TfNSW Reference: SYD25-00446/02
DPHI Reference: SSD-81434988

**ADVICE ON ENVIRONMENTAL IMPACT STATEMENT
ALSPEC MANUFACTURING WAREHOUSE
221-227 AND 289-317 LUDDENHAM ROAD, ORCHARD HILLS**

TAB A – TfNSW advisory comments

Figure 5-3 Network layout for the assessed intersection at Luddenham Road and Patons Lane

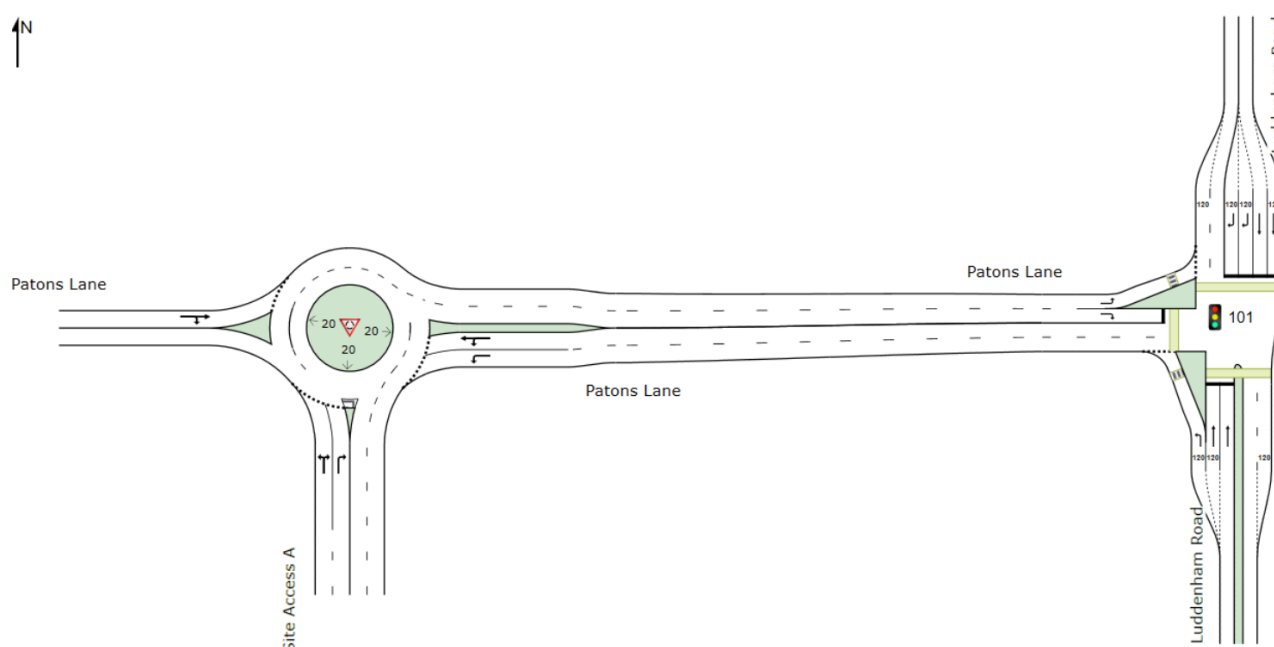
TfNSW notes that the application proposes the upgrade of the Luddenham Road/Patons Lane intersection with traffic signals. The project timeline indicates that the intersection will be upgraded in 2026, prior to the occupation of the first warehouses in the estate. Whilst TfNSW do not object to the proposed traffic signals in principle, in accordance with section 87 of the *Roads Act, 1993* traffic signals can only be approved by TfNSW, and to date TfNSW have not provided any approval for the traffic signals to be installed.

To enable an approval in principle for the installation of traffic signals, TfNSW requires:

- an updated Warrant Assessment in accordance section 2.3 of the RTA Traffic Signal Design Guide, which includes the cumulative traffic of other developments that will use the Luddenham Road / Patons Lane intersection
- a concept design for the proposed traffic signals designed in accordance with TfNSW Traffic Signal Design Guide requirements be submitted to TfNSW for review.
